**WELWYN HATFIELD COUNCIL – DEVELOPMENT CONTROL**  
**DELEGATED REPORT**

<b>APPLICATION No:</b>	<b>N6/2009/1054/LB</b>
------------------------	------------------------

Listed building consent is sought for the partial demolition of the rear element of the listed building as well as internal alterations to enable the building to be used for community use (D1 use – place of worship). The application is presented alongside a Listed Building Statement prepared on behalf of the applicant by their consultant DPP Heritage.

WGC AL (0) 260

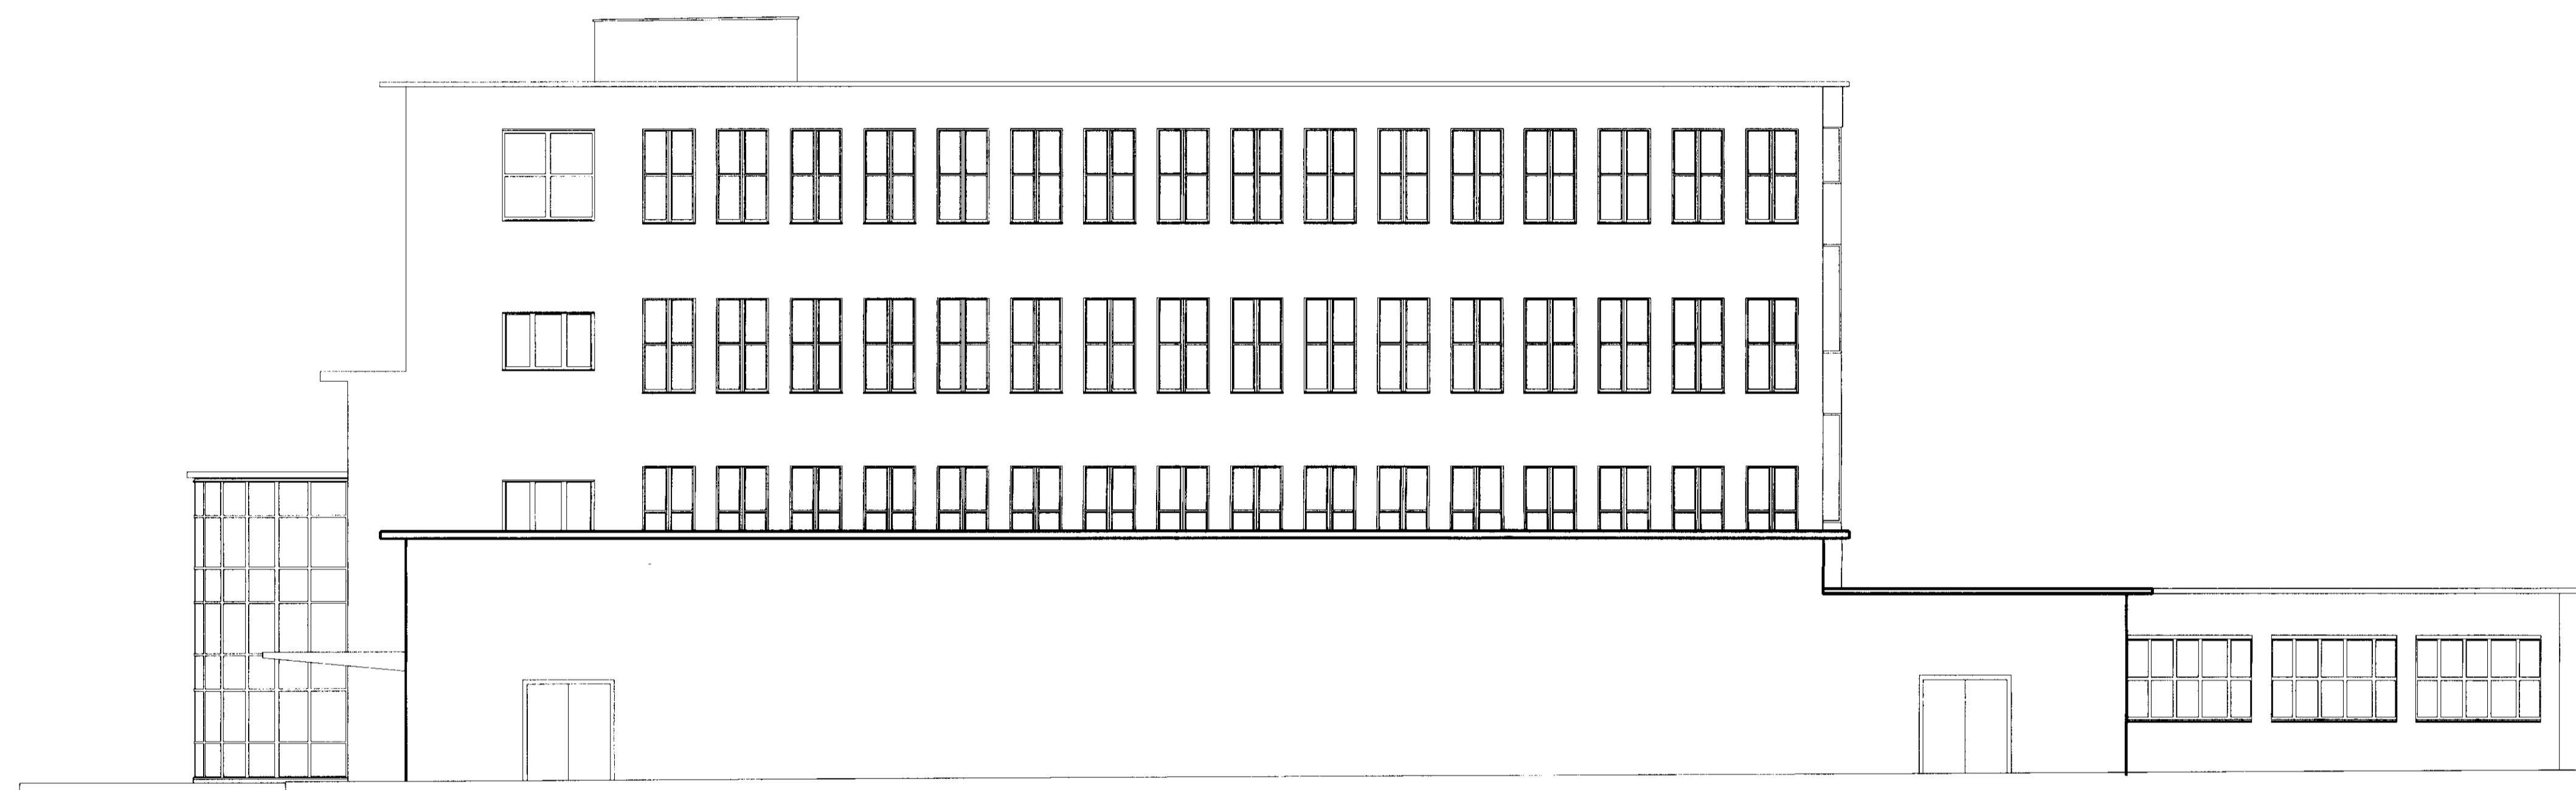
Some discussion was had with regard to the design approach to the rear (west) elevation that is to be made good following the demolition of the 1950s addition, and ultimately it is considered that the proposed blank façade would be appropriate given the proposed use of the room (which will serve as the main congregational hall for the church) and the character of this building given its strong minimalist composition. However, details and the final making good of this elevation would need to be conditioned.

4. Notwithstanding the details shown on the approved drawings listed in condition 2 above, no works shall take place until detailed plans of the west elevation are submitted to and agreed in writing by the Local Planning Authority. The required plans shall be submitted at 1:5 scale illustrating the detail of the proposed new door openings, frames and doors as identified on approved drawing WGC AL (0) 260. The works shall then be implemented in accordance with these approved details.
